PATRICK HARRON AND ASSOCIATES COMMENT REVIEW TRACKING FORM

Project: Forest Creek Estates, Lot 4; 5202 Forest Ave SE Mercer Island, WA 98040

DATE: 9/15/20
 SCALE: AS SHOWN
 DRAWING NO: **C1.0**
 1 OF 5

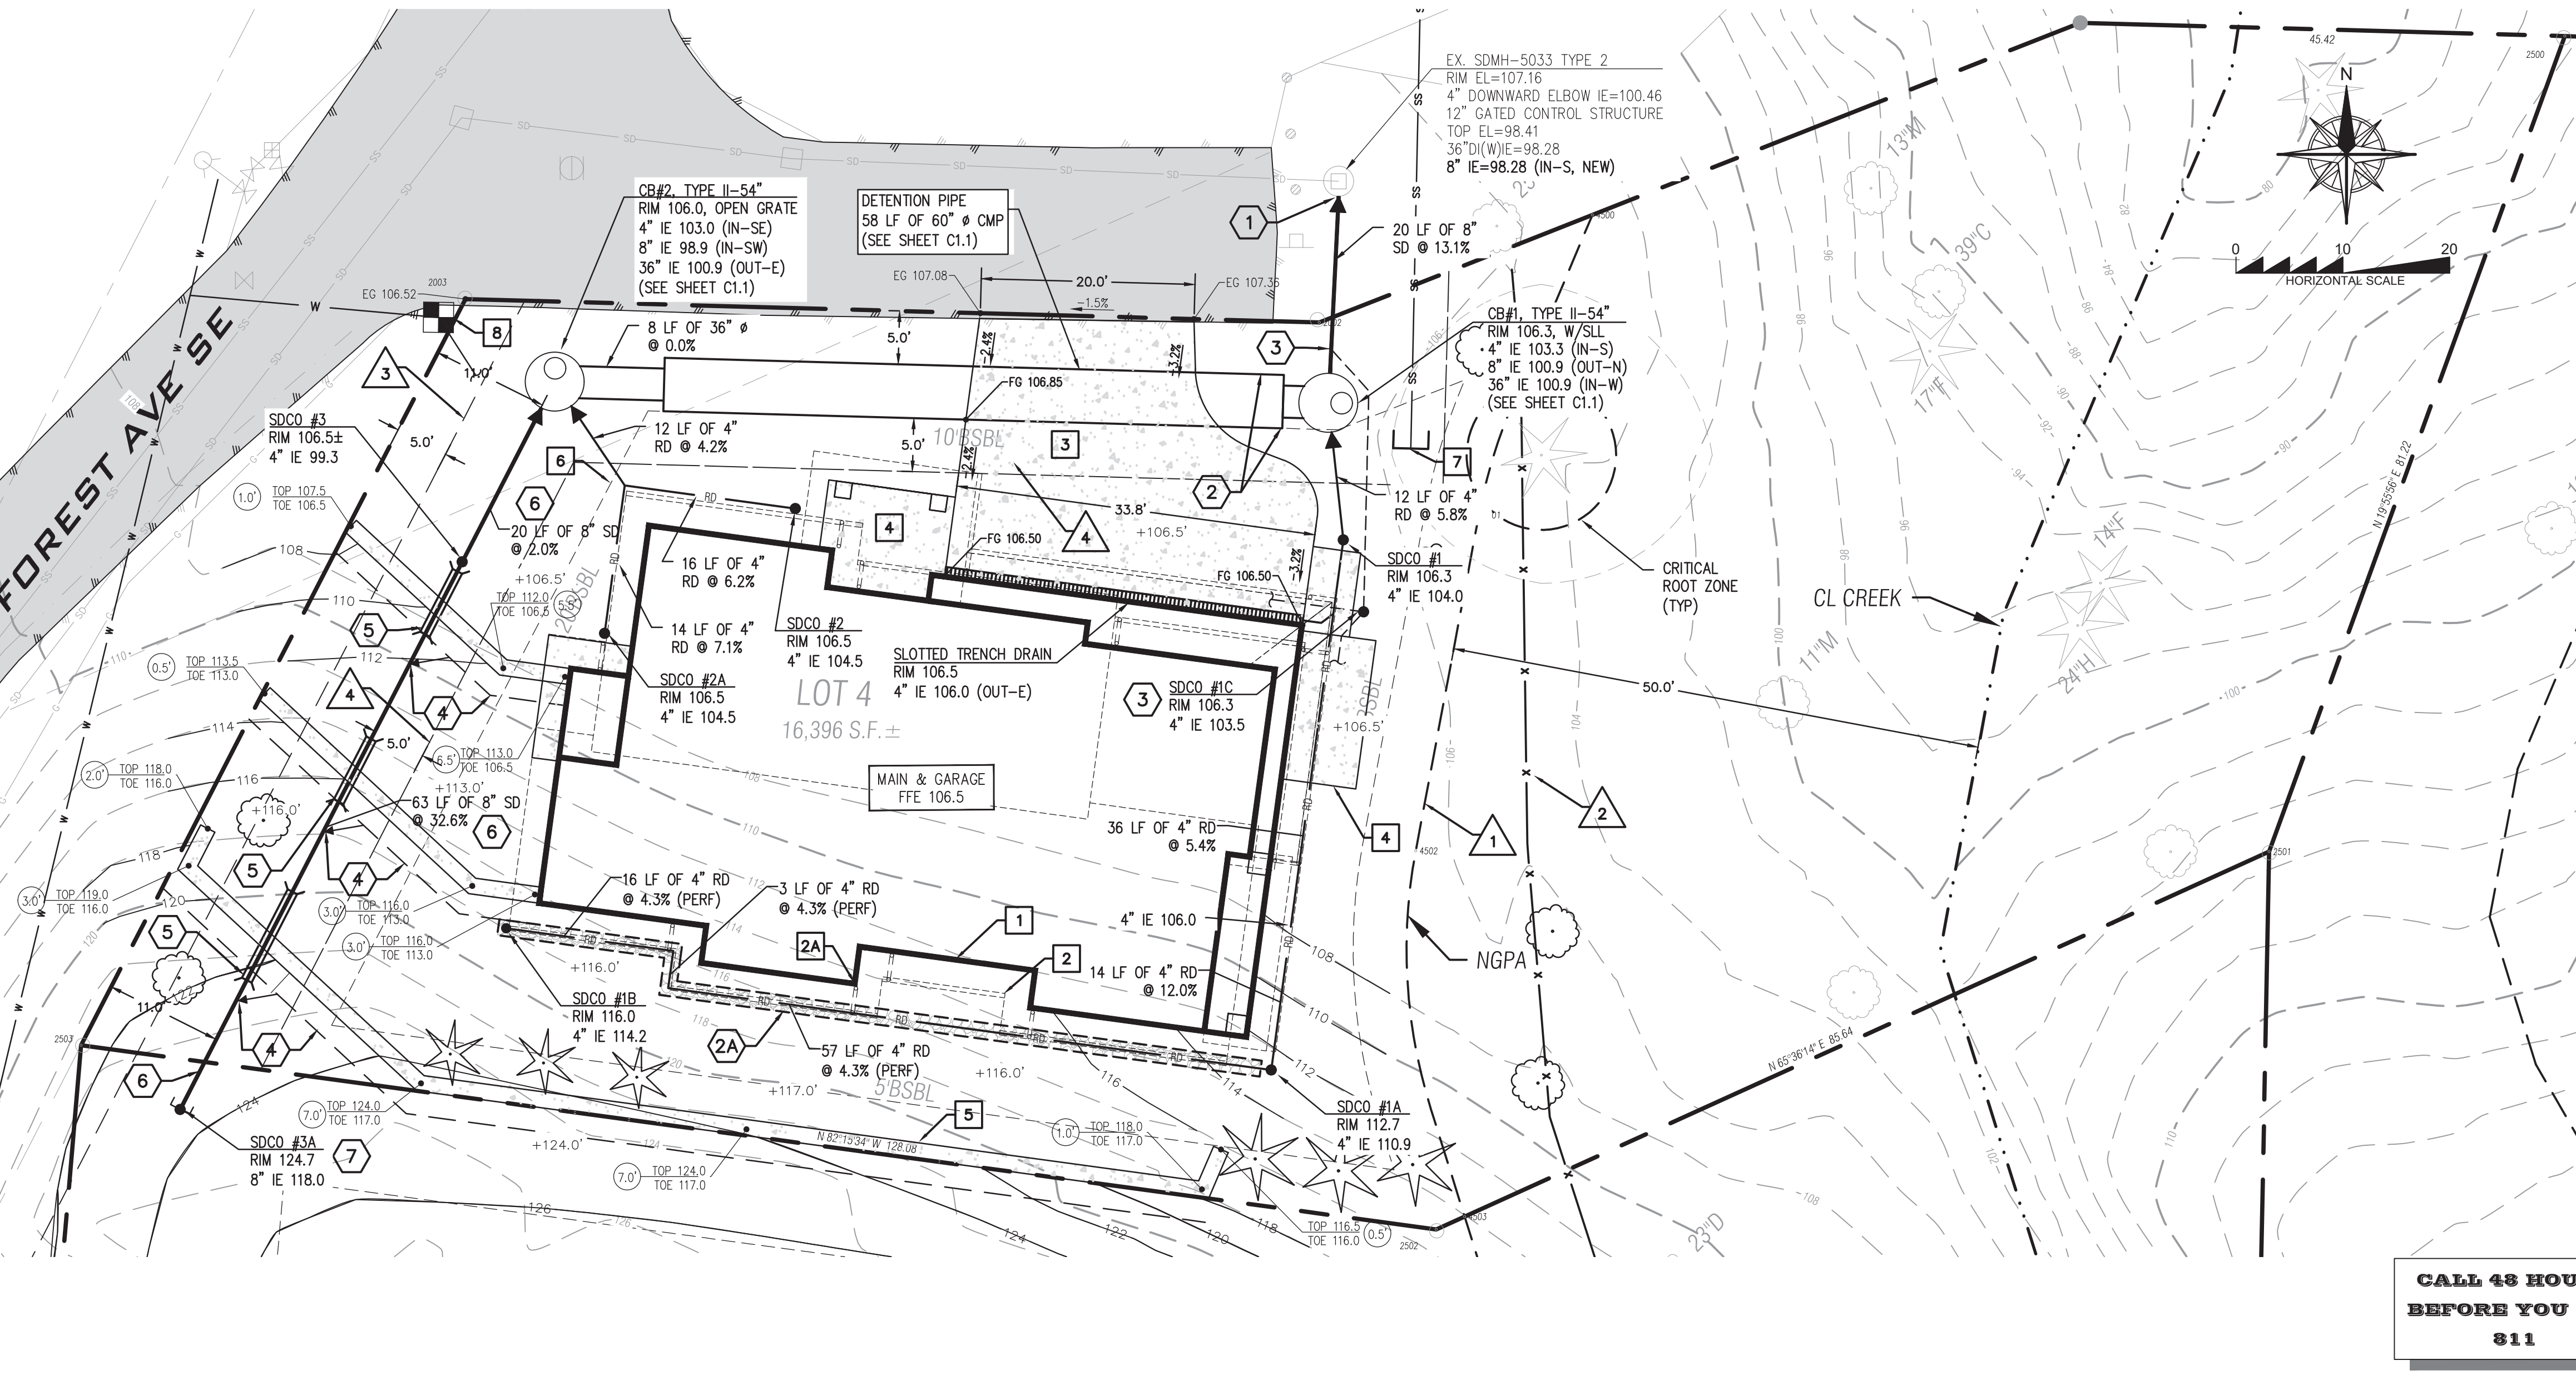
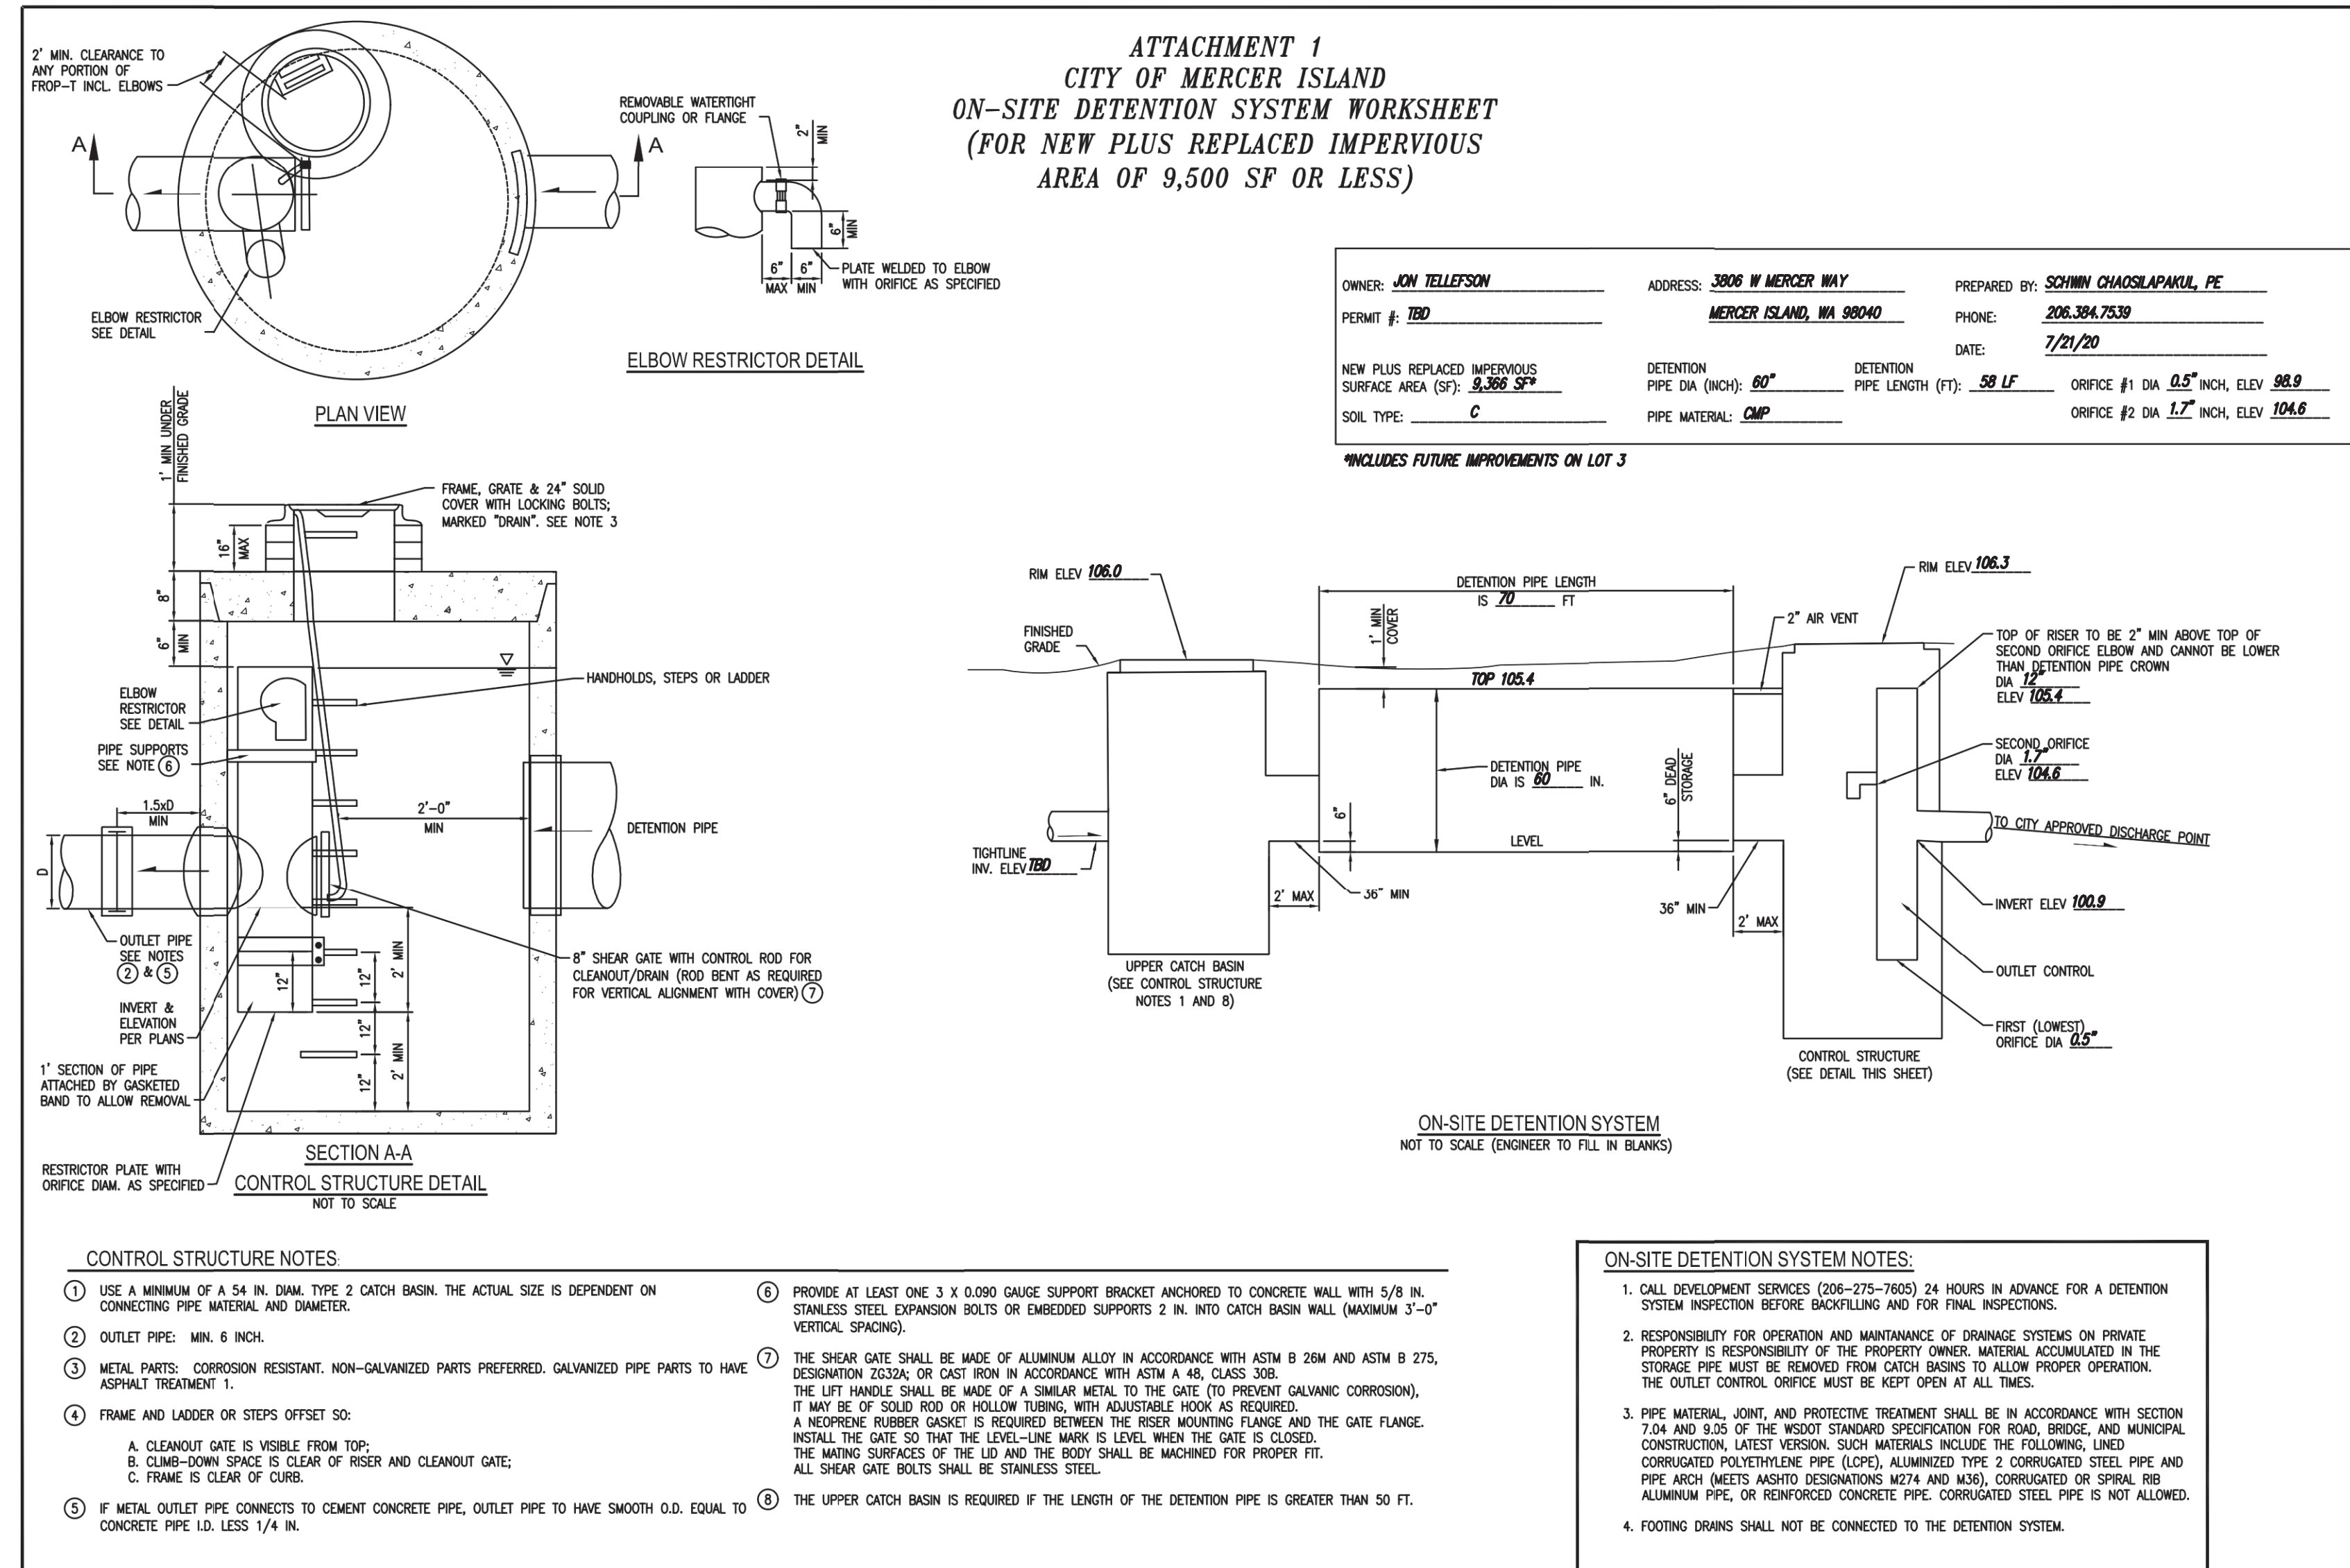
Comment No.	Sheet No.	Date	Comment By	City Comment	PHA Response
1	C1.0	12/15/2020	RD	This is the control structure for the existing city detention system. The discharge from the private detention system cannot connect to the control structure. The discharge point must be downstream of the control structure. Please show the existing drainage system downstream of this system.	An additional structure added downstream of the existing city detention system control structure.
2	C1.0	12/14/2020	JK	10 ft	N/A Comment provided for scale bar check.
3	C1.0	12/14/2020	RD	The existing water meter cannot reused, as it was installed prior to 2014 prior to Federal No-Lead Law. The new water meter and water service can be located at the same location. Please revised the note.	Noted in Water Callout #8.
4	C1.0	12/14/2020	JK	3. (From Intake for Civil) Show all tree information shown on A1.2. on civil sheet C1.0. Or put all civil layer on tree plan. Utilities must be outside of tree protection zone. And over excavation for detention to not encroach into area. Call this out.	Revised critical areas and easment callouts note #1 as follows: <i>"Native growth protection area (NGPA) buffer. All utilities must remain outside of NGPA buffer. Over excavation for detention pipe shall not encroach into area. "</i>

5	C1.0	12/14/2020	RD	Please show the invert elevation at the side sewer stub out, the sewer invert elevation at the building, and the detail connection between the house and the existing stub out, any cleanouts,etc.	Will comply. Will add additional information including slopes and lengths to new sewer design.
6	C1.0	12/14/2020	RD	Do you have a footing drain for this house? If so, please provide the design.	Yes, this house does have footing drains. We have provided the connection to our storm system, however the footing drainage system itself has been detailed by the structural engineer. Storm Callout #3 has been revised as follows: <i>"4" FOOTING DRAIN SYSTEM TO EXTEND AROUND BUILDING PERIMETER. LOWEST IE TO BE 105.2. CONNECT TO 8" STORM SYSTEM ONSITE PER PLAN @ 2% MIN. REFER TO STRUCTURAL PLANS FOR FOOTING DRAIN DETAILS. "</i>

Comment No.	Sheet No.	Date	Comment By	City Comment	PHA Response
7	C1.0	12/14/2020	RD	Is there a drainage system associated with those walls? If so, please provide design.	<p>Yes, this property does have retaining wall drains. We have provided the connection to our storm system, however the footing drainage system itself has been detailed by the structural engineer.</p> <p>Storm Callout #4 has been revised as follows: <i>"4" PERFORATED WALL FOOTING DRAIN SYSTEM TO CONNECT TO 8" STORM SYSTEM AT 2% MIN. AT APPROXIMATE LOCATION SHOWN. REFER TO STRUCTURAL PLANS FOR WALL FOOTING DRAIN DETAILS."</i></p> <p>Invert elevations at proposed connections have been called out.</p>
8	C1.0	12/14/2020	RD	Please remove all work on lot 3	Done.
